**KIRKLEES METROPOLITAN COUNCIL
INVESTMENT & REGENERATION SERVICE**

DELEGATED DECISION TO DETERMINE PLANNING APPLICATIONS

Reference No:	2023/62/93336/W
Site Address:	17, Whitehall Road, Linthwaite, Huddersfield, HD7 5PN
Description:	Erection of two storey side and single storey rear extensions and porch to front elevation.
Recommending Officer:	Laura Yeadon

DECISION – Conditional Full Permission

client	MR ROSS NAYLOR		
project	EXTENSIONS TO 17 WHITEHALL ROAD LINTHWAITE HUDDERSFIELD HD7 5PN		
drawing	PROPOSED PLANS AND ELEVATIONS		
revision	notes	date	drawn
scale :	1:50 AT A1	11.23	PB
project no.	drawing no.	revision	
2312	02

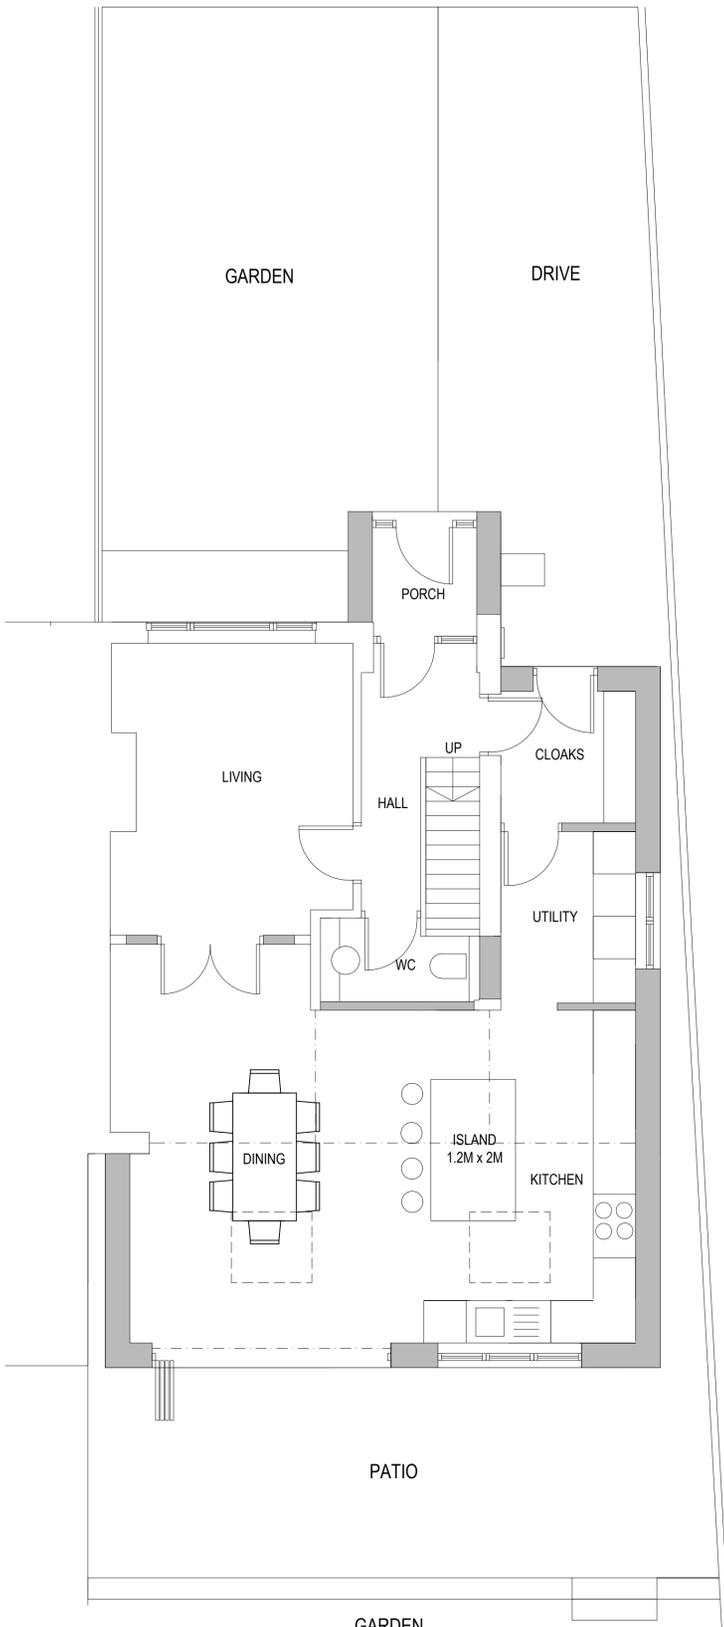
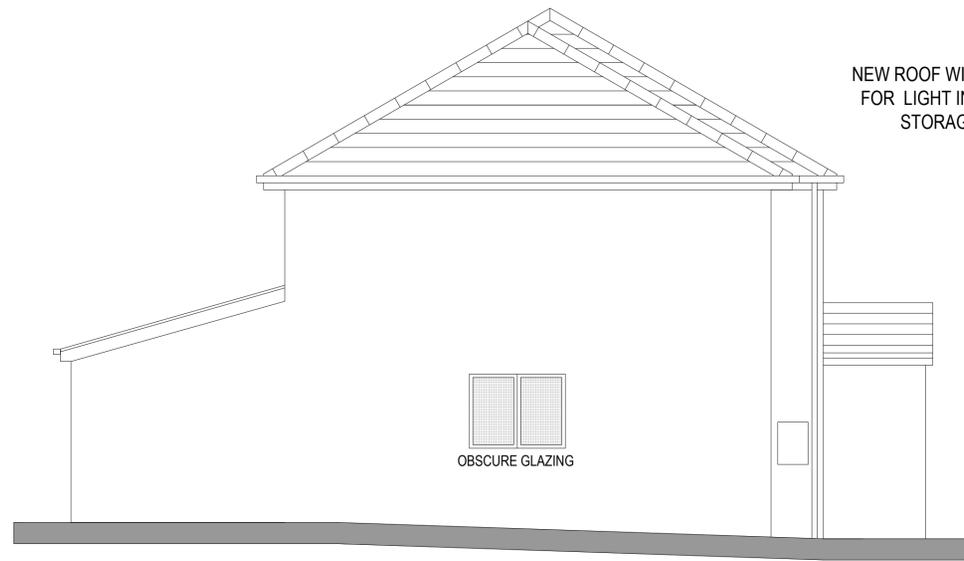
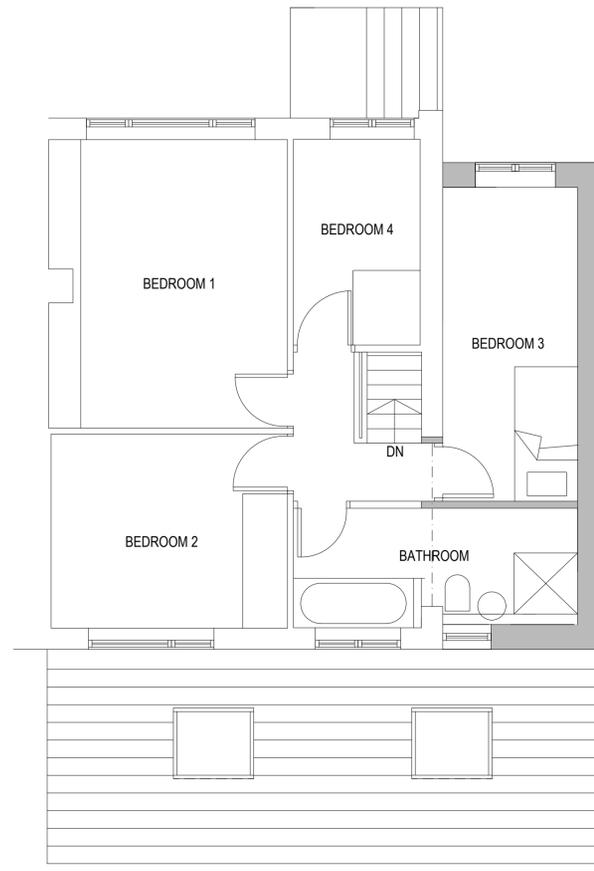
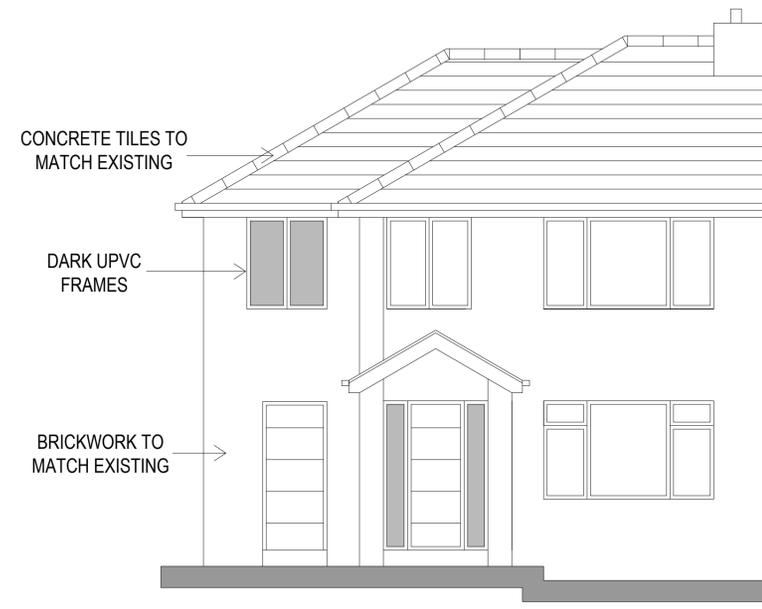
The visual impact of the works have been designed so that the two storey side extension would be set back from the front elevation of the existing property by more than the 500mm required by the SPD and has a roof line which is set down from the existing. Whilst it is noted that the proposal would not maintain a gap of 1 metre between the side wall of the side extension and the shared boundary, due to the significant difference in ground levels and proposed roof form, a sense of space would be retained between the application site and No. 15. It is therefore considered that this element of the scheme is acceptable and would be subservient to the host dwelling and is not dissimilar to the side extension to No. 13. Whilst the proposed side extension does not strictly comply with the requirements of the SPD, justification for the scheme in terms of its similarity to No. 13 and No. 1 Whitehall Road has been submitted and therefore, the proposed works,, in this isolated case, are considered acceptable within the remit of Key Design Principles 1 and 2 of the SPD.

In terms of the proposed single storey rear extension, this would have a total projection of 3 metres which would be built up to the shared boundary with the attached neighbouring property, No. 19. The proposed single storey rear extension would be in keeping with the scale and size of the original house; would not cover more than half the total area around the house; would not exceed more than 4 metres in height and; would not have a projection of more than 3 metres. In this respect, the extension complies with paragraph 5.6 of the SPD. It does not comply with the final section of this section of the document

that states that a gap of at least 1 metre should be retained from a property boundary. It is proposed that the extension would be built up to the boundary with No. 19. The property hosts full permitted development rights and could, subject to criteria, construct a 3 metre projecting extension, up to the shared boundary without the requirement of planning permission. As there is a realistic fall-back position in this case, it is considered that there is adequate justification to construct up to the boundary line in this case.

The proposed porch would be identified as a front extension in terms of the SPD. The proposed porch would be set well back from the pavement, is small and subservient to the host property, the materials would match the existing and it is considered that the porch would not unreasonably affect neighbouring properties. Therefore, compliant with the SPD.

There are proposed openings within the ground floor side elevation facing No. 15 to the proposed utility room. However, it is proposed that these would be obscurely glazed and therefore mitigates any harm from overlooking at close quarters from this elevation, there is also a significant difference in levels between the properties.

Roof lights are also proposed within the rear elevation roof slope to provide light into the loft area which is annotated on plan to be used for storage. Given the nature of roof lights, within a sloped roof, it is not considered that these would cause undue harm from overlooking, therefore compliant with Key Design Principle 3 of the SPD.
